July 15, 2020

Re: Phase II Alteration Level 2
3100 Manual NE, 87107
30-Day Temporary Certificate of Occupancy
Transportation Development Final Inspection
Engineer's/Architect's Stamp dated 8-9-20 (H16D153)
Certification dated 7-7-20

Ernie Gomez,
Plan Checker, Planning Dept.
Development Review Services

C-102

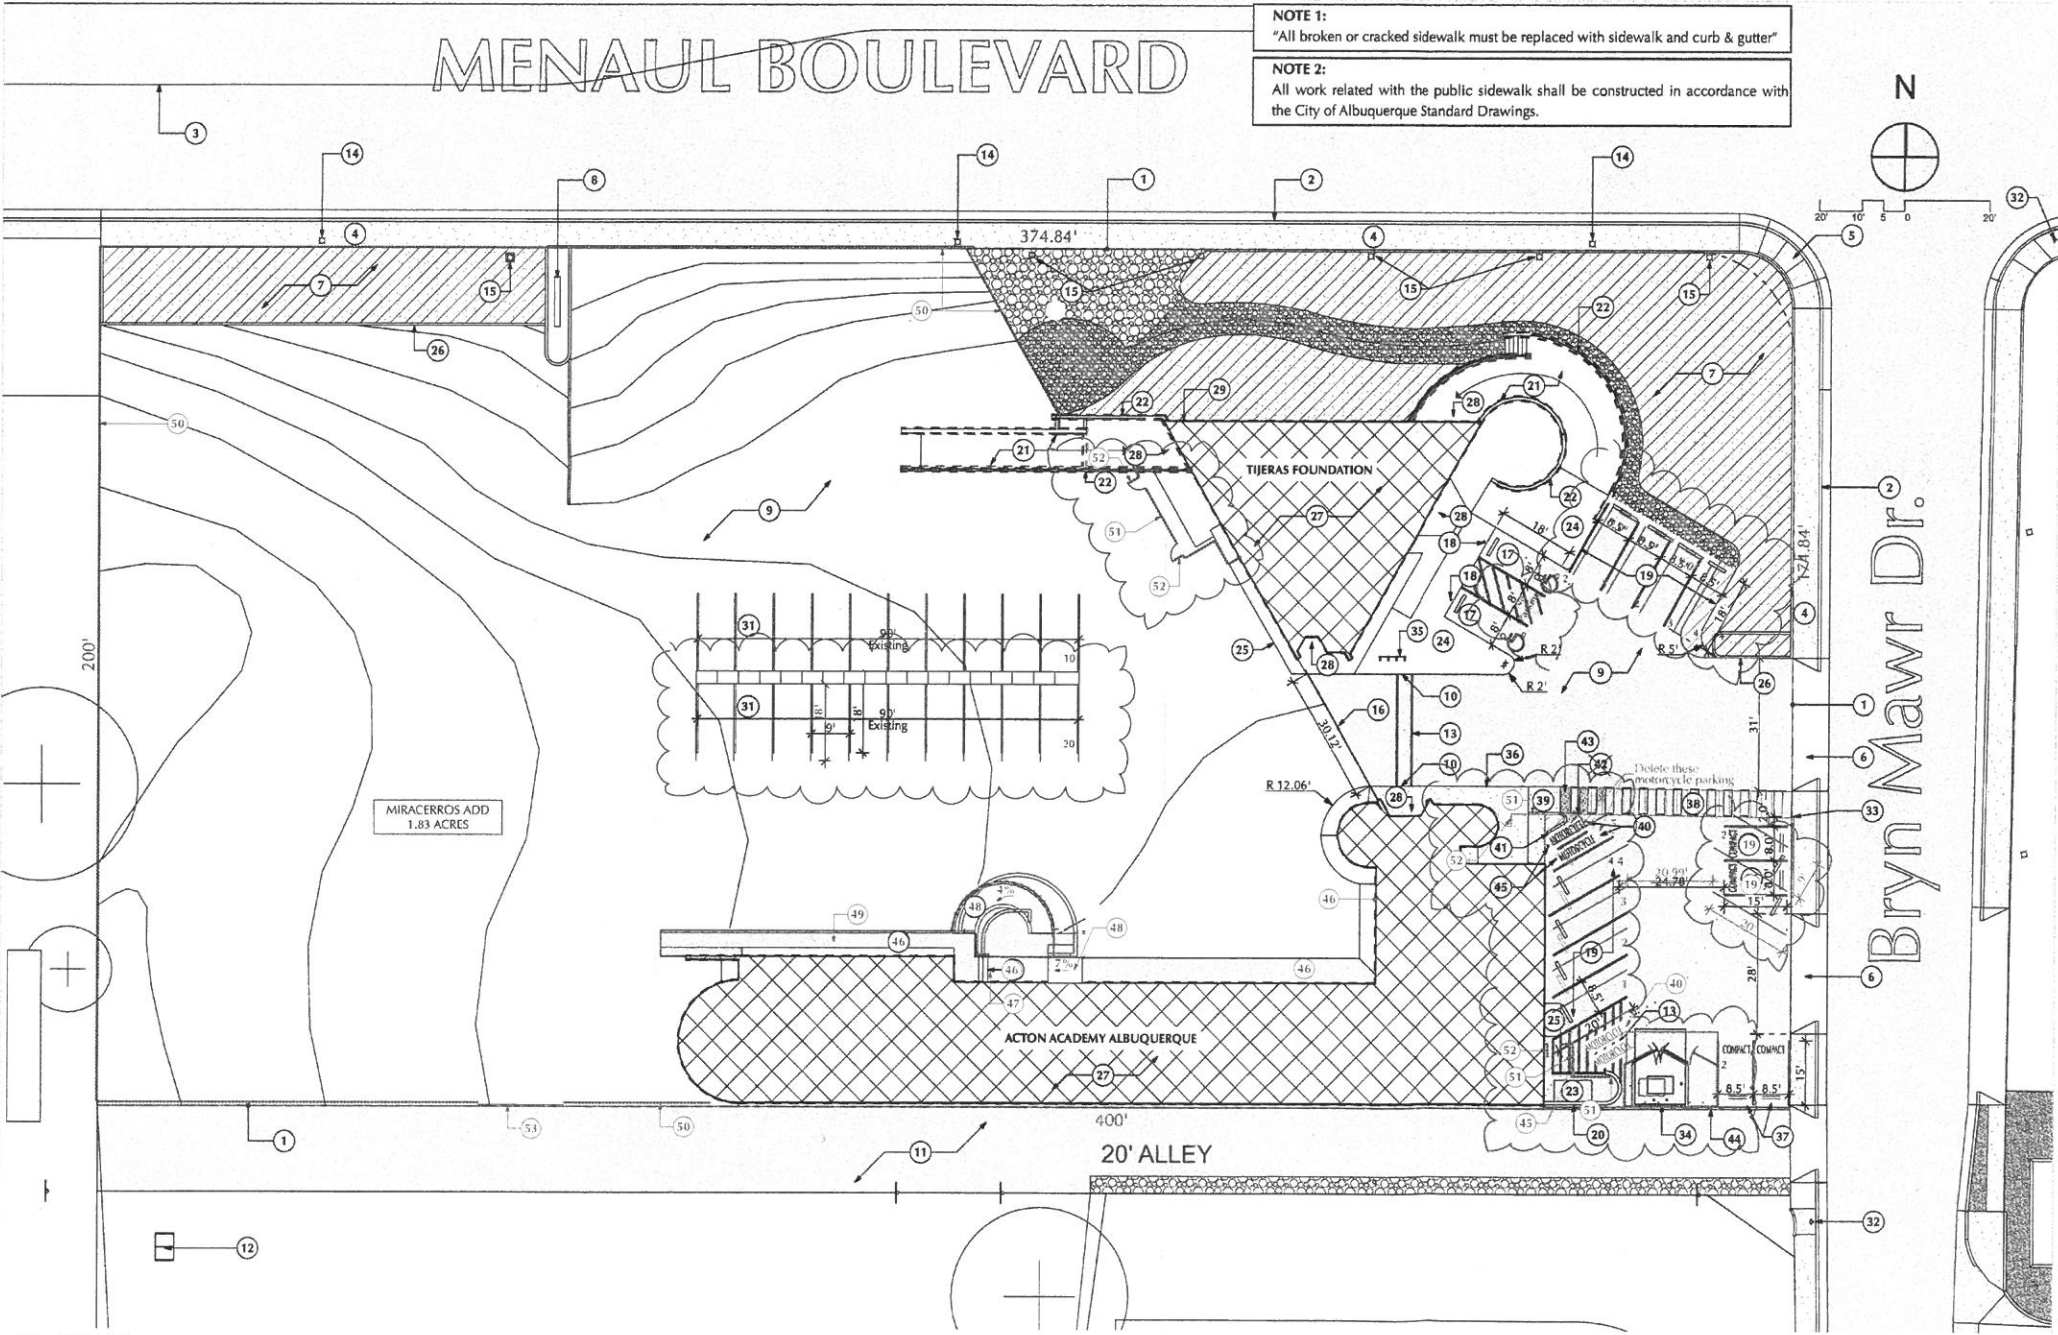
- Please correct parking stalls in back for correct length. 18 foot minimum length. (Measured 12 feet in length)
- The ADA access aisles shall have the words **"NO PARKING"** in capital letters, each of which shall be at least one foot high and at least two inches wide, placed at the rear of the parking space so as to be close to where an adjacent vehicle's rear tire would be placed. (66-1-4.1.B NMSA 1978)
- Please update plan to reflect all changes. 2 parking stalls fronting Bryn Mawr Dr. changed to angled please add Compact to stalls and reflect changes on plan.
- Please stripe ADA walk path from sidewalk to building entrance (6 foot Minimum). Please remove bollard blocking ADA pathway to building entrance.
